Dear Nell:

Thank you for the opportunity to summarize some of the concerns I have been discussing with you over the past several months for presentation to the Planning Board.

I am disappointed that I am not able to attend the October 25th hearing. Thus, I offer the following additional thoughts:

UTILITY & STORMWATER MANAGEMENT PLAN

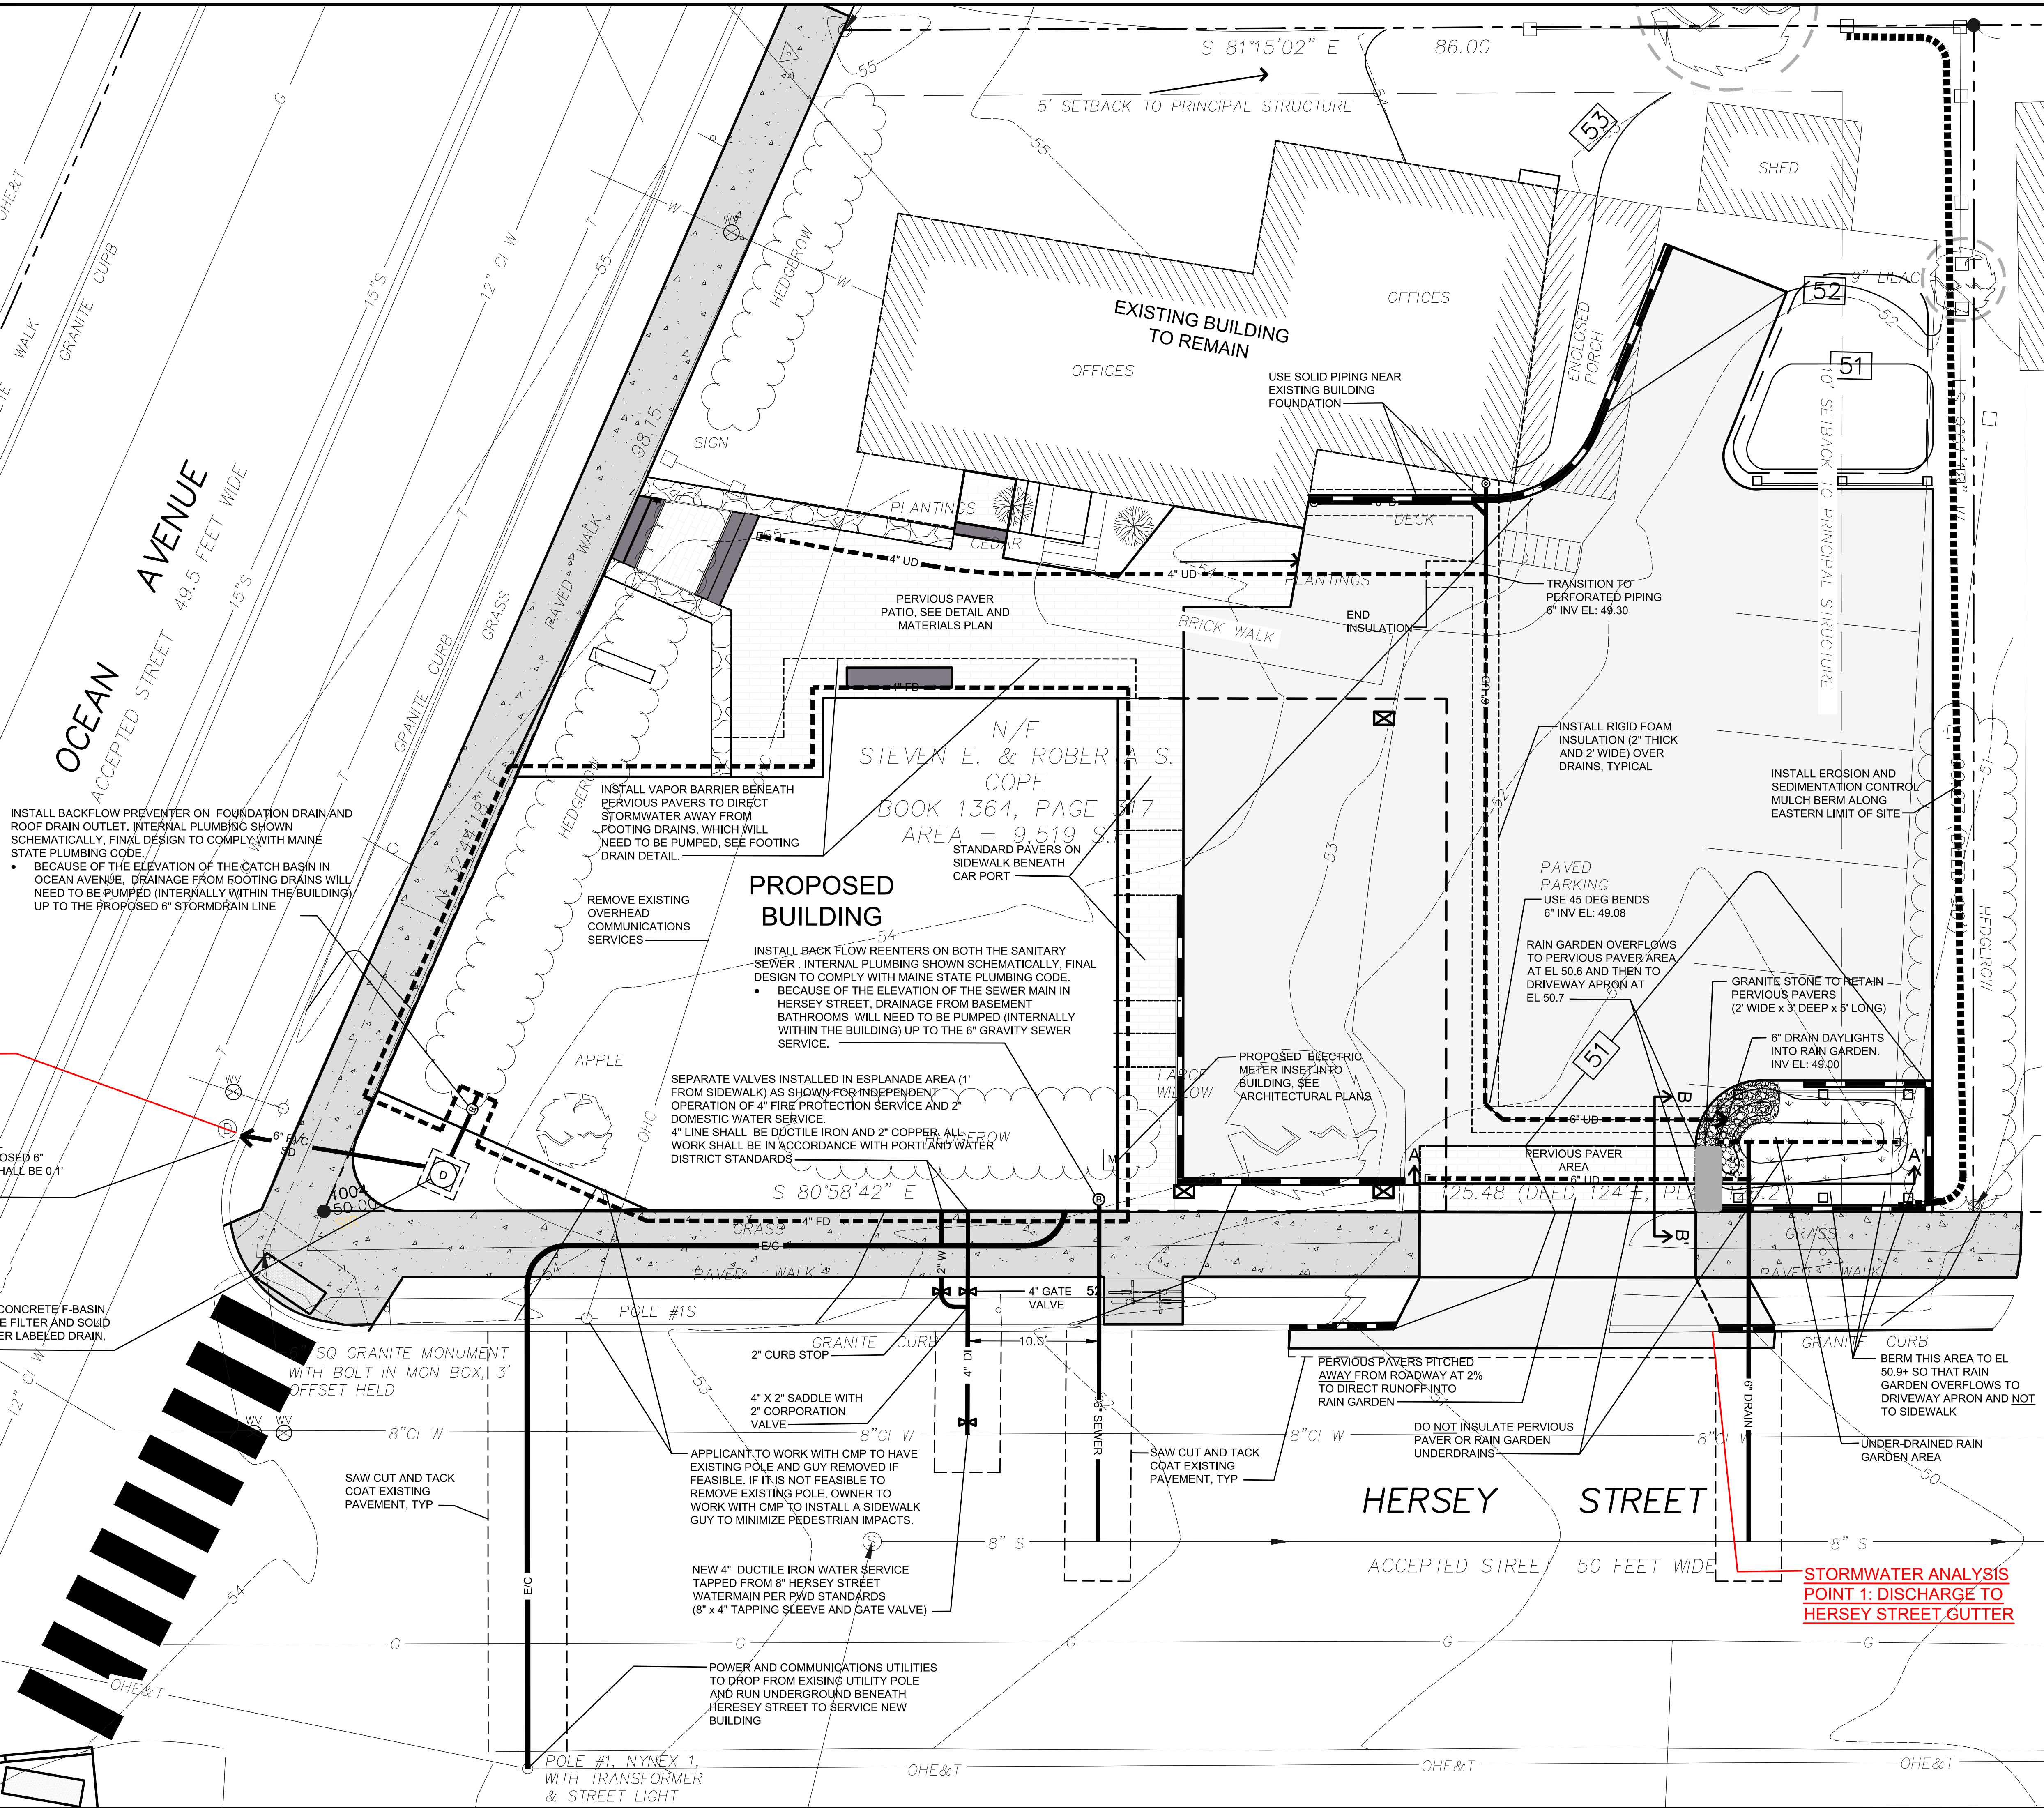
3. **The current combined stormwater/sewerage pipe on Hersey Street** is under capacity (and illegal) and floods homes with sewerage, condoms, needles, and more, even with moderate rainfall and melting snow. It is greatly appreciated that after our making Planning aware of the problem, that most is being redirected to Ocean Ave. However, we submit that ANY additional runoff is a huge problem. Thus, the Waiver for flooding should be DENIED.

23 OCEAN AVE
PORTLAND, ME
PRELIMINARY SITE LIGHTING

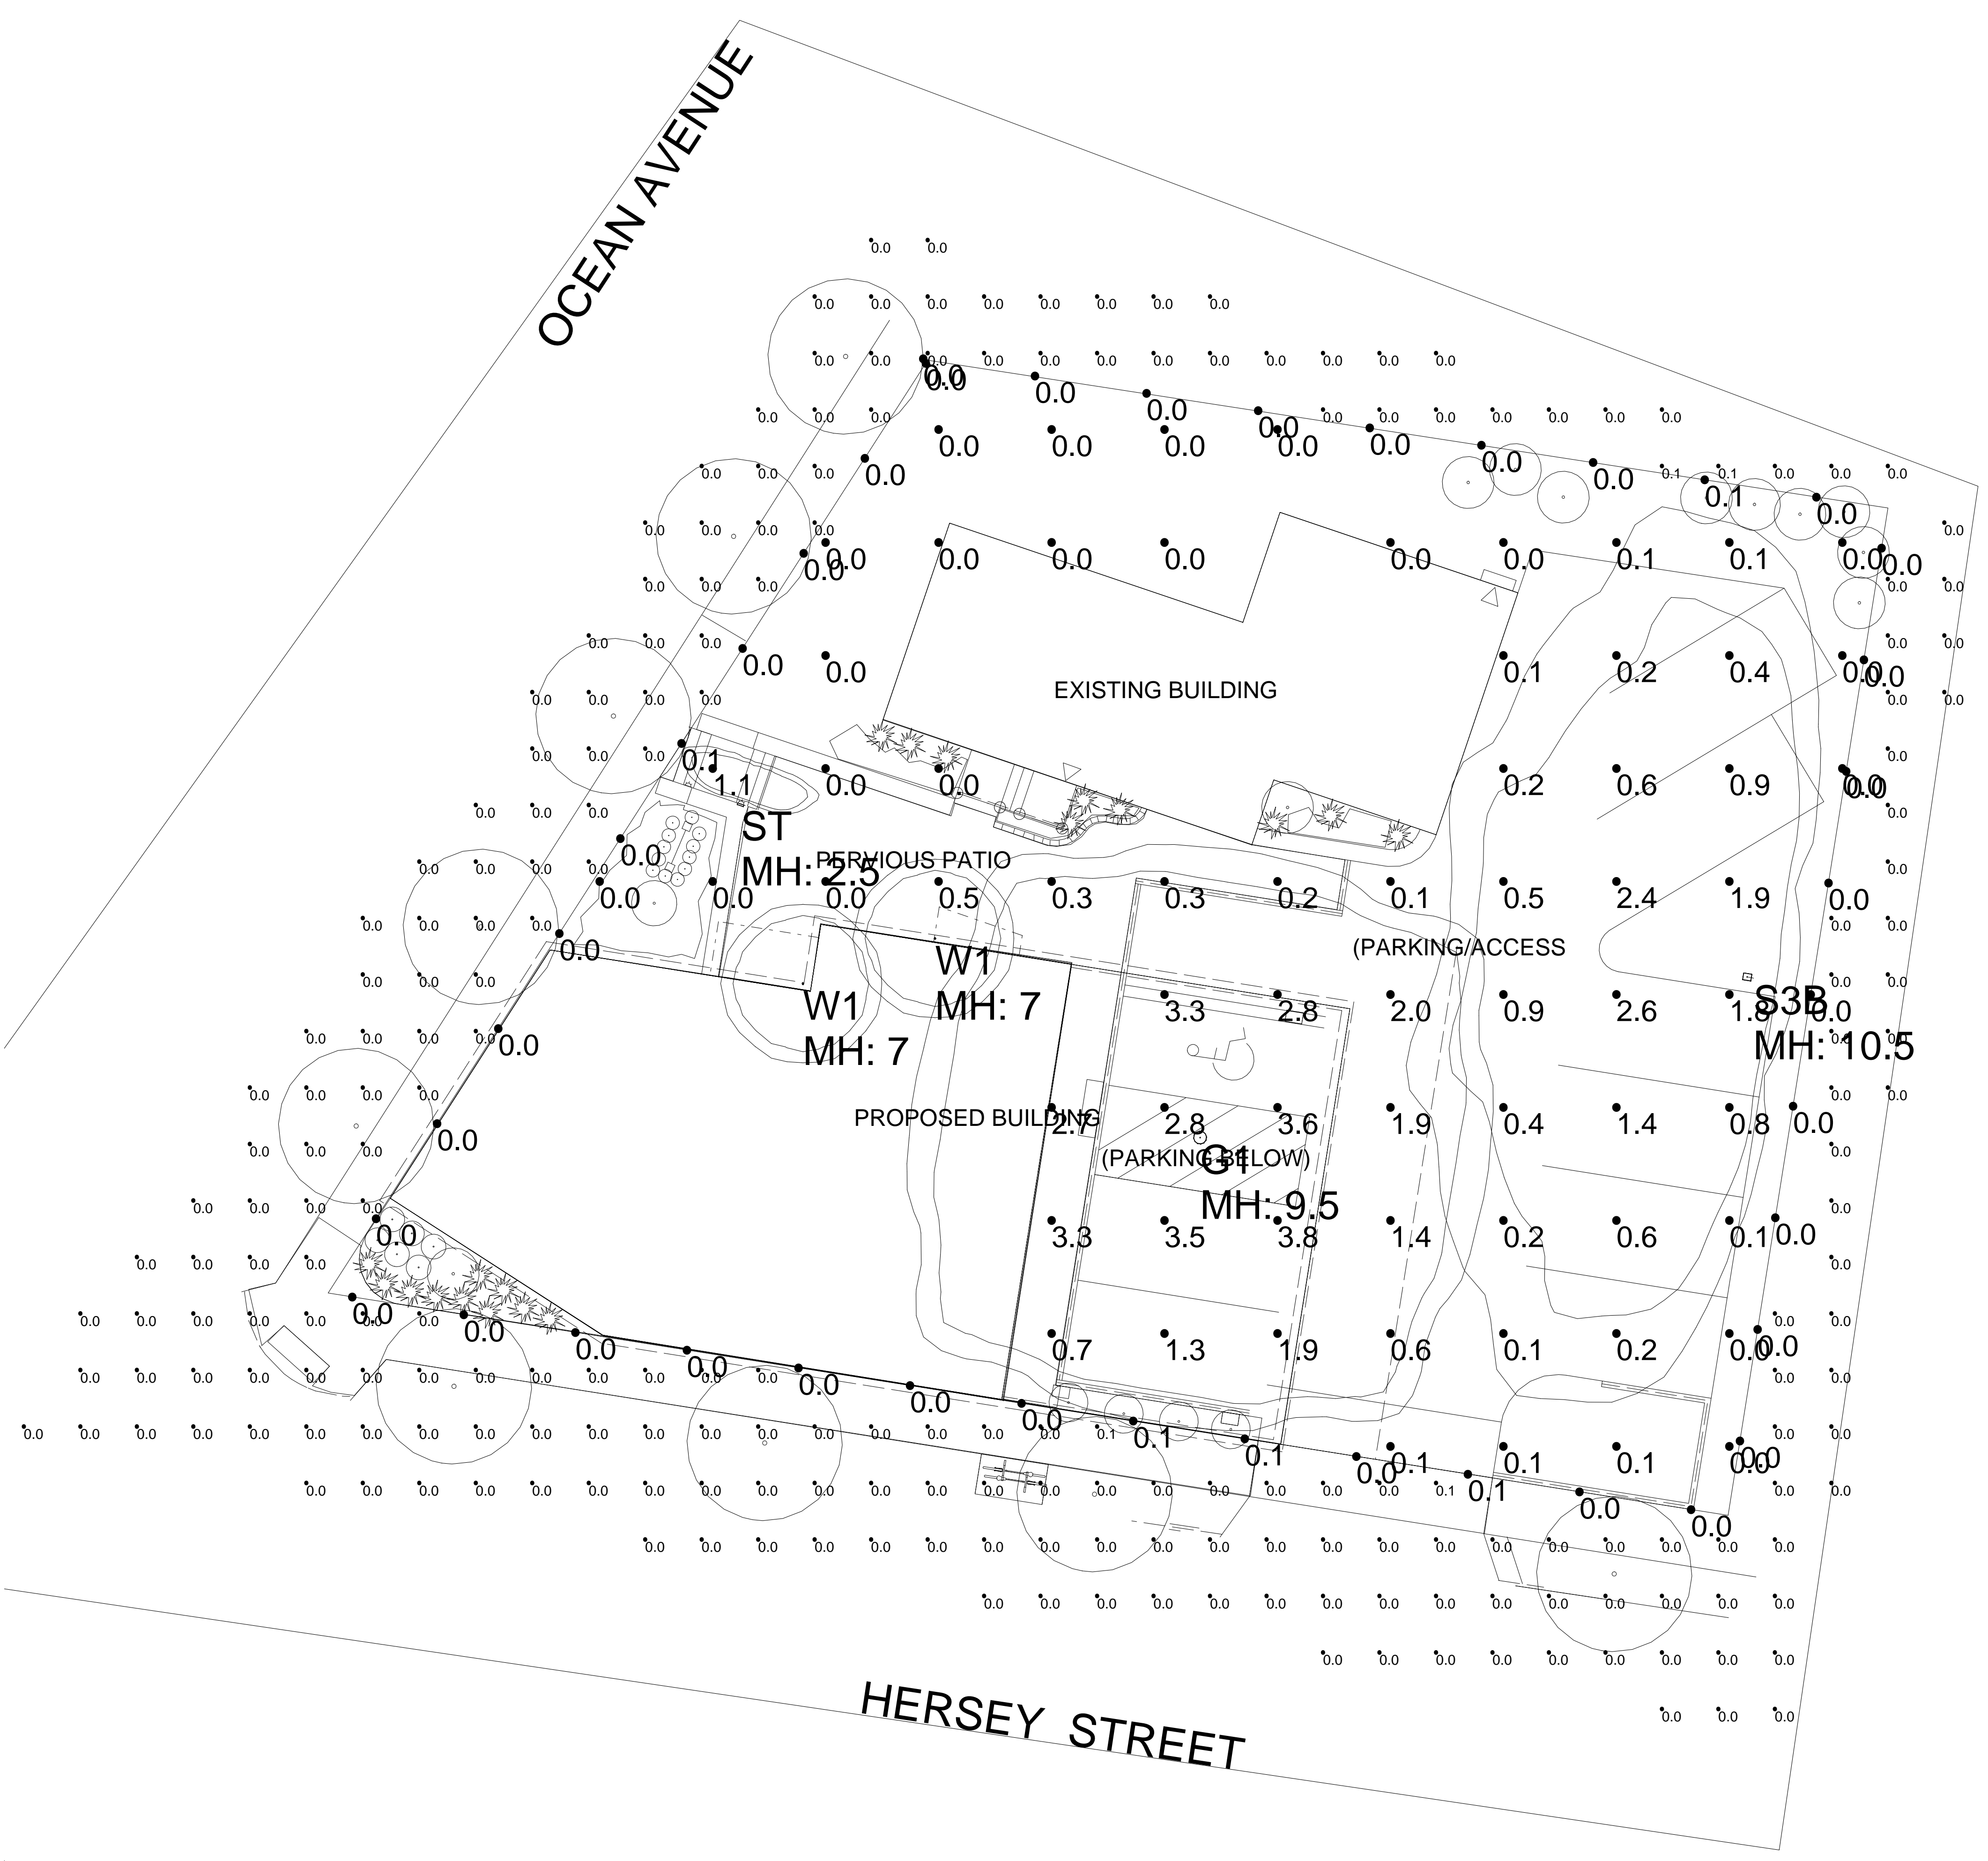
12. Has the applicant submitted a **photometric plan** that demonstrates there will be no LIGHT SPILLAGE on to adjacent properties and that all lighting is shielded and shines downward?
